From: Martyn White
Sent: 04 September 2020 13:36
To: Planning.Responses
Subject: BR/147/20/PL

BR/147/20/PL

53 High Street Bognor Regis PO21 1RX

Conversion of first & second floor & rear extension to create 4 No. 1-bed self--contained flats including the demolition of existing rear extension & erection of two storey rear extension. This application may affect the setting of a listed building & may affect the character & appearance of The Steyne, Bognor Regis Conservation Area

Proposed Front
Elevation
Scale 1:100

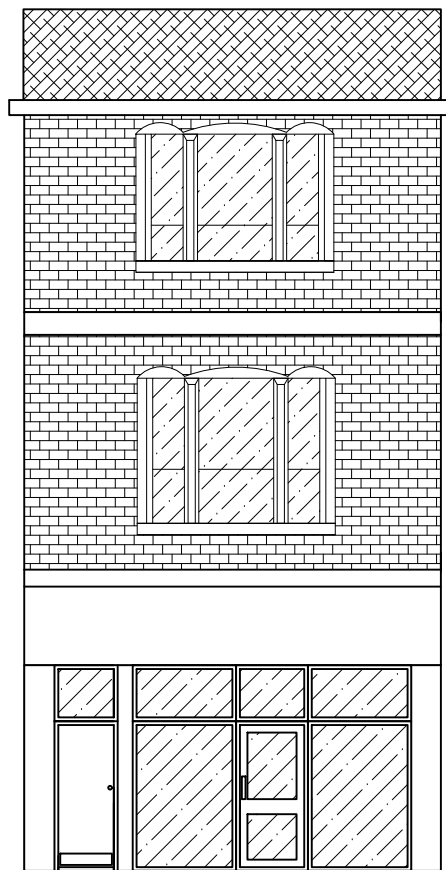
The retention of the traditional features such as the windows is also supported, and it is suggested that the two string course items should also remain. The replacement shop front will be of aluminium construction, which is unfortunate, as there is the opportunity to re-introduce a lost feature of the elevation. However, if carefully detailed it could be a positive impact, whilst also reflecting a number in the immediate area.

Proposed Rear
Elevation
Scale 1:100

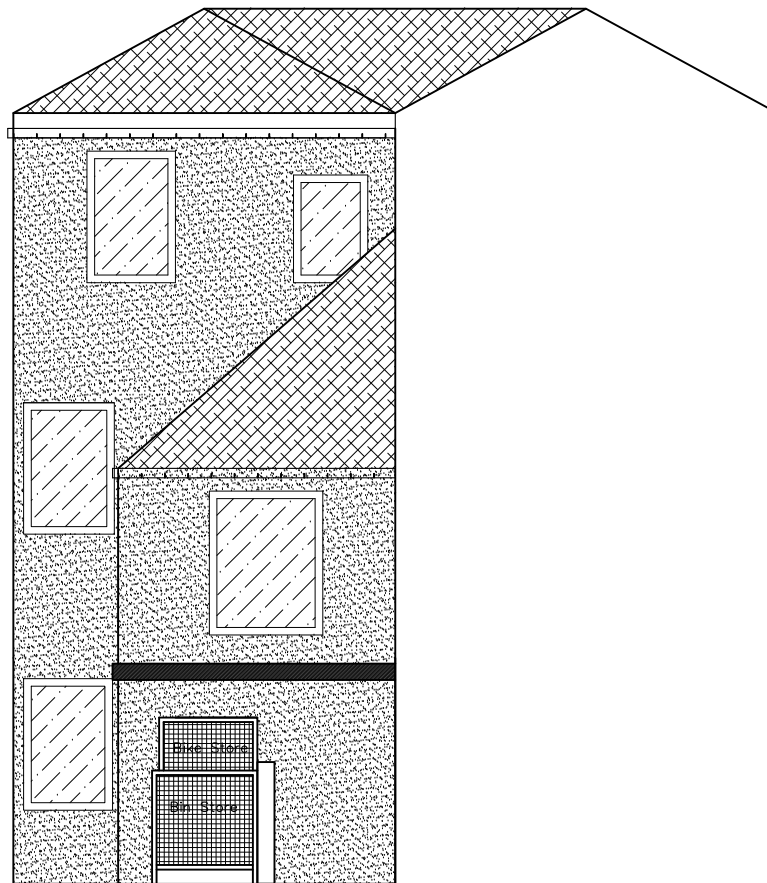
Likewise, the proposed extensions are located so as to not be visible in the context of the heritage assets, and as a result will have a neutral impact.
